International Chinese School State Significant Development SSD-10260

14 April 2020

Agency Submissions

Figure 46: Proposed site plan. (Source: Stanton Dahl Architects)

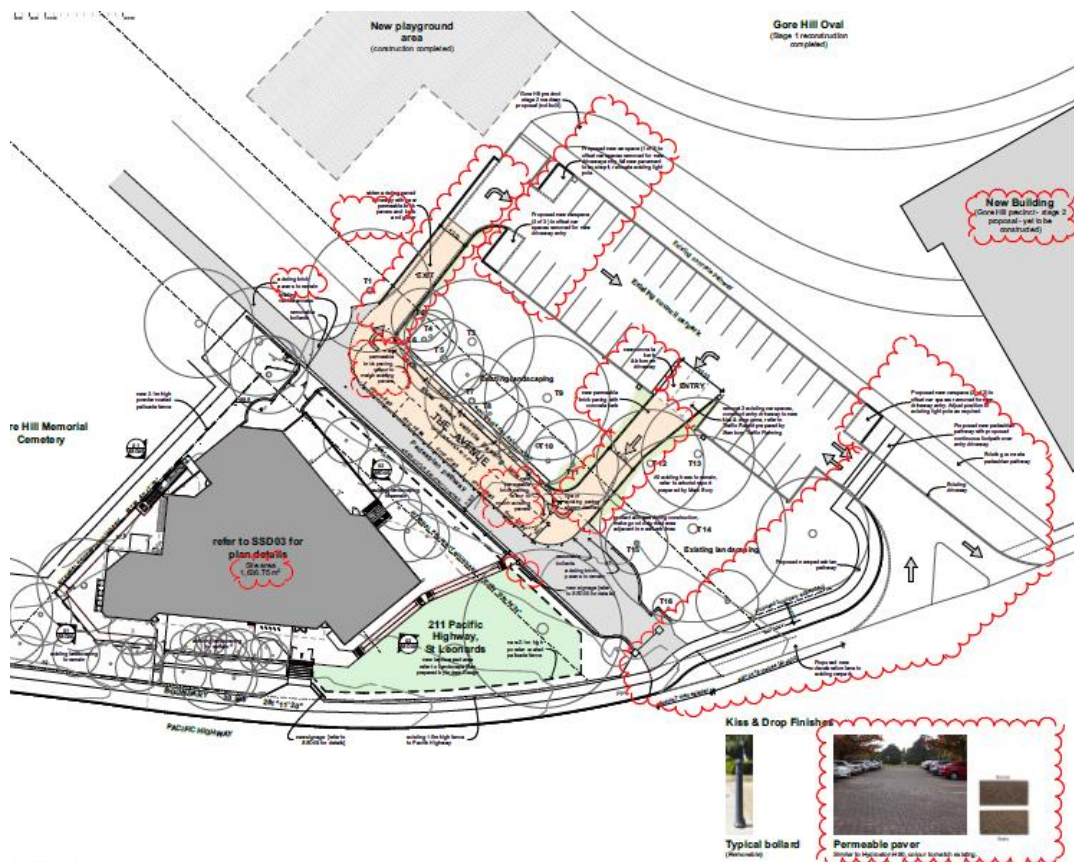
3	<p>The Department considers that the extent of proposed paving for the five 'Kiss and Drop' spaces shown on drawing No. SSD01 and its proposed charcoal colour would significantly alter the appearance and visual consistency of The Avenue resulting in significant impacts on the physical and visual character of the state heritage item. The Department is concerned that the Heritage Impact Statement (HIS) prepared by 'NBR Architecture' has not accurately ascertained the extent of new paving proposed and has not therefore provided a proper assessment of heritage impact. The Avenue currently contains a combination of paving, soft gravel</p>	<p>The existing pavers and paving layout dates from the 1970s and is not considered a significant design element of The Avenue.</p> <p>The colour of the new paving has been reconsidered and is now shown in the revised Site Plan. It provides a similar colour material to the existing 1970s paving. The retention of existing paving retains the visual uniformity of paving along the length of The Avenue.</p>

Number	Submission	Response
	and grass in uniform proportions along the majority of its length towards to north. Drawing No. SSD01 incorrectly notates the area of soft gravel and grass adjoining the pedestrian pathway as 'line of existing paving'. The HIS states that proposed works include "re-laying of existing paving". This description is inaccurate as the soft gravel and grass is proposed to be replaced with charcoal coloured paving bricks, resulting in a fully paved area between the school site and Council car park which significantly departs from the character of the ground surface treatment along the remaining length of The Avenue.	The outline of the existing paving is defined by a brick header course where it abuts the new paved area. The new paved area is in an area of gravel with limited seasonal grass growth due to heavy shading and no reticulation. It extends the area of full-width paving at the southern end of The Avenue. The revised Site Plan at Appendix B clarifies the extent of existing and new paving. The landscaped border with existing mature trees is retained between The Avenue and the Council carpark retaining principle design element of The Avenue as a tree-lined boulevard.

6	A second building identification sign is shown on drawing No. SSD01 to be constructed adjacent to the pedestrian entrance on The Avenue. The EIS and HIS document one sign only and the second sign facing The Avenue has not been considered in the HIS or EIS with respect to its visual impact to the state heritage item. Further, the sign appears to be located in an area which is currently provided with dense shrubs. Clarification of the number of signs proposed and the potential heritage impact of an additional sign facing the Avenue should be addressed in the RtS. This should include any details of vegetation impact.	<p>The heritage assessment included at Appendix D outlines that both proposed signs will have a negligible heritage impact by not detracting from the heritage significance of the place.</p> <p>An assessment of vegetation impacts from the proposed signage has been provided for within an Arboriculture Statement prepared by Mark Bury at Appendix G. The report outlines that the proposed works will not have any adverse impacts on the existing shrubbery, with the exception of required light pruning when necessary.</p>

TITLE  
PAVEMENT DETAILS SHEET 1

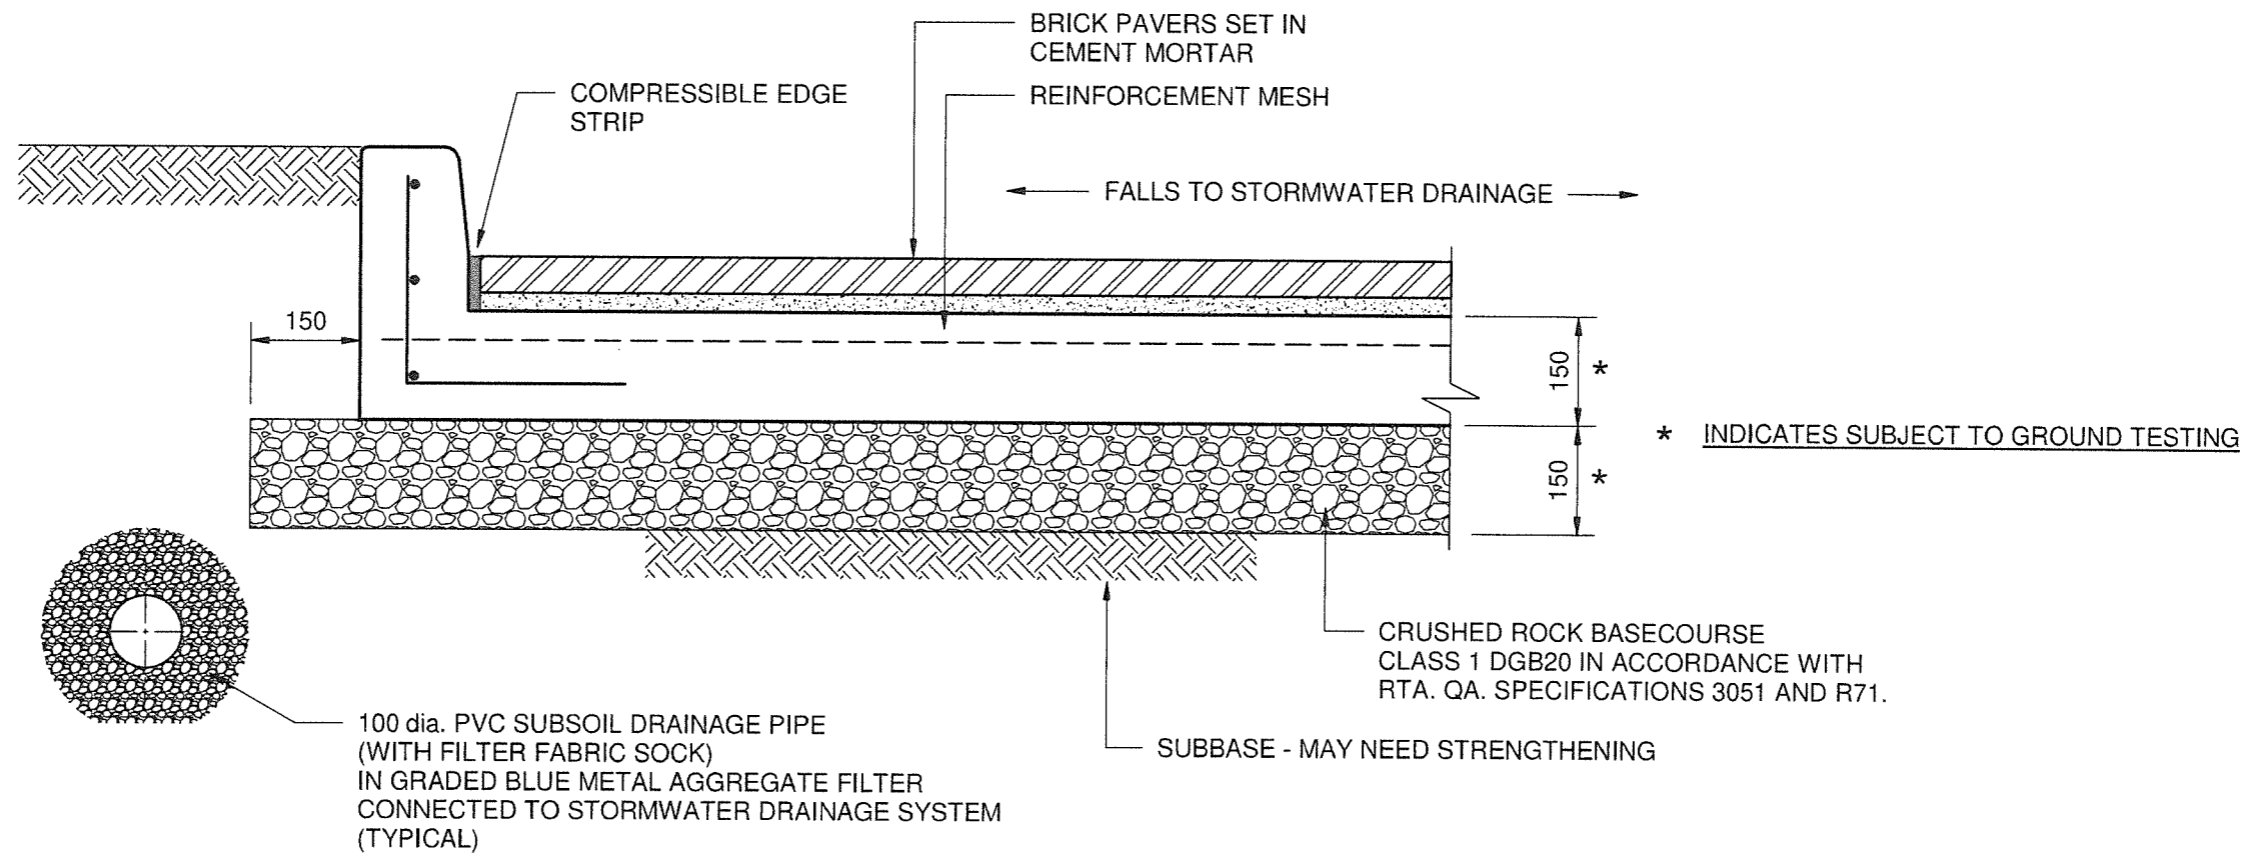
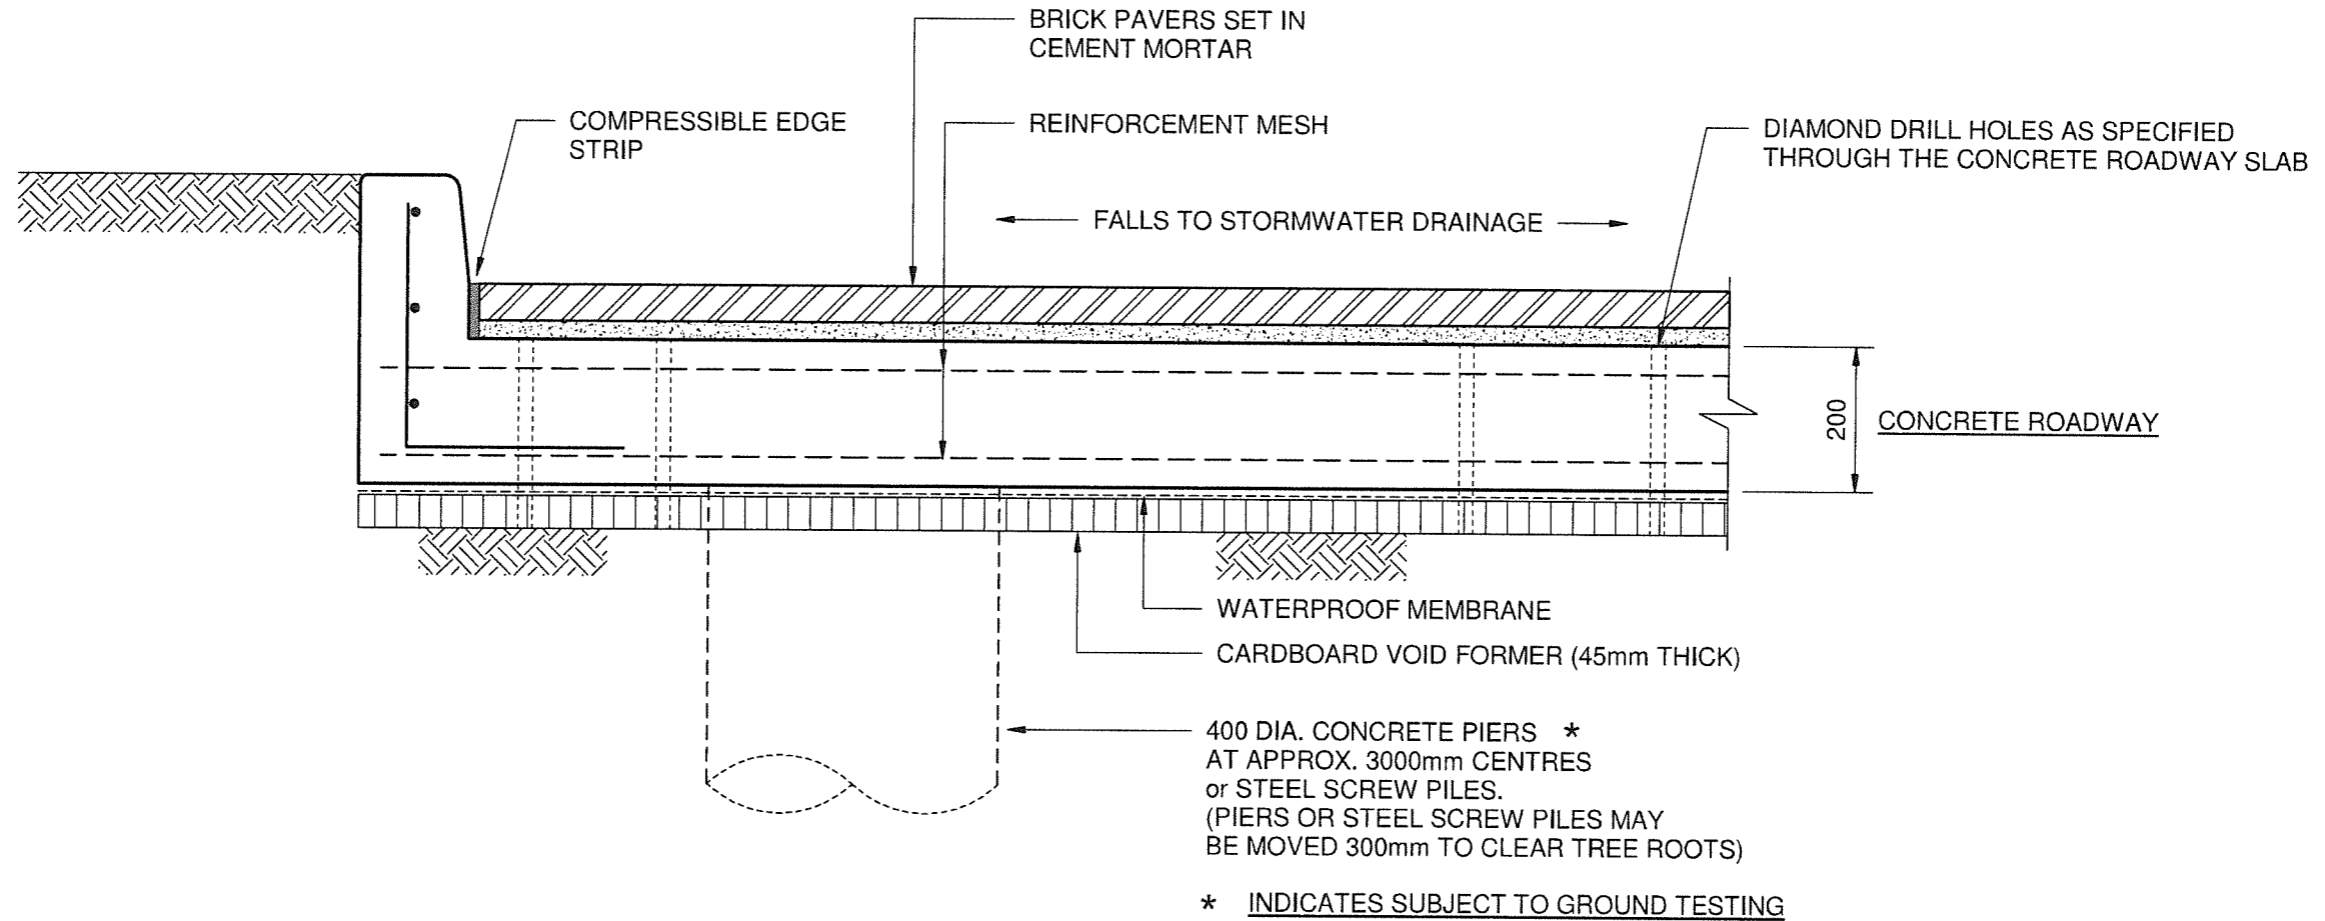
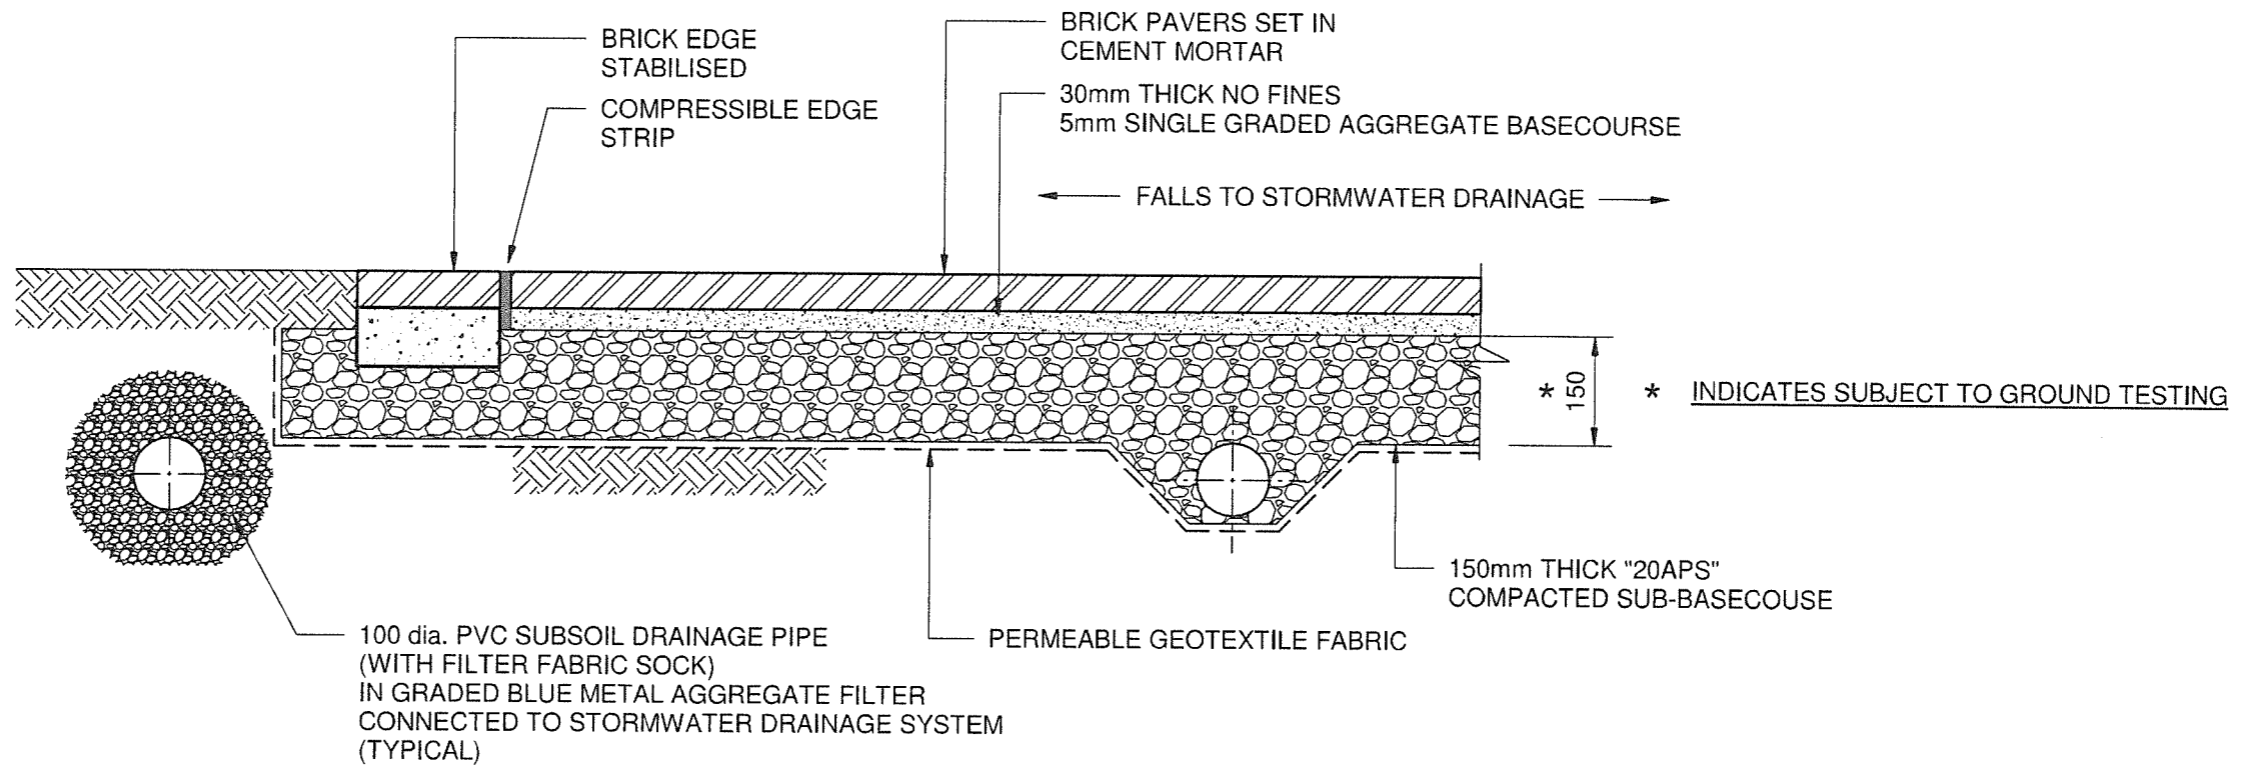
4	Further, although indicated on drawing No. SSD01, the EIS has not discussed the proposed paving works to The Avenue in full detail.	Noted. A civil engineering report and sketches are provided for within Appendix F which outline the paving works in further detail.
5	The HIS notes that part 3.3 of the Gore Hill Memorial Cemetery Plan of Management (POM) requires that vehicular access on The Avenue be restricted to maintenance vehicles only and for access across The Avenue to the site's car park (from the existing car park driveway). The HIS then asserts that the vehicular use of the 'Kiss and Drop' area is supported by the POM as it provides access to the site. This is an incorrect interpretation of the POM as the existing access across The Avenue to the site is through the existing 'two way' driveway opposite the site's carpark entrance. The construction of an additional driveway into The Avenue to provide 'one way' access to a new 'Kiss and Drop' area and a 'one way' exit through the existing driveway would introduce new vehicular movements along and through The Avenue, in contrast to the current arrangement where access to the site requires vehicles to traverse across The Avenue. Further, the intensity of use of the 'Kiss and Drop' area during morning and afternoon peaks is at odds with the intent of the POM, which aims to minimise vehicle use and impacts within The Avenue and on the state heritage item. The RtS should include an addendum to the HIS which addresses the above.	<p>The POM Strategy and Action - Infrastructure item 3.3 establishes vehicular access is to be maintained to the Sextons Cottage site. It does not limit this access to a single point or explicitly prohibit development.</p> <p>The POM provides precinct plans for development in the burial areas but no specific guidance for development of The Avenue or Sextons Cottage. It does however explicitly support the increased activation of the cemetery in order to facilitate the ongoing conservation and maintenance of the place.</p> <p>The additional single driveway required for the Kiss and Drop function does not detract from the dominant physical element of the tree-lined boulevard. It is limited to a short length of The Avenue adjacent to Sextons Cottage, Gardener's Shed, Pacific Highway, the Council carpark, Gore Hill Park Sporting Complex and the children's playground. This area is currently the most active area of The Avenue. It is currently subject to regular vehicular traffic and informal carparking.</p> <p>The proposed use of the area is limited to short morning and afternoon drop-off and pick up times which occur on less than 55% of days in the year. This limited use is not considered to at odds with the POM strategic goals to both limit vehicular access and to provide activation of the cemetery to provide financial support for its ongoing conservation.</p>

23	<p>The impact on vegetation, including the root zone of adjacent trees, by constructing a second access to The Avenue to serve the proposed school. The survival of vegetation in this area, being the Gore Hill Park precinct next to a State Heritage Item, is considered an important consideration and should not be jeopardised.</p>	<p>An Arboriculture assessment prepared by Mark Bury Consulting has been provided for at Appendix G. Investigations indicate that the proposed construction methodology of the second access driveway is acceptable and will not cause any adverse impacts to the root zones of vegetation along the second entry.</p>
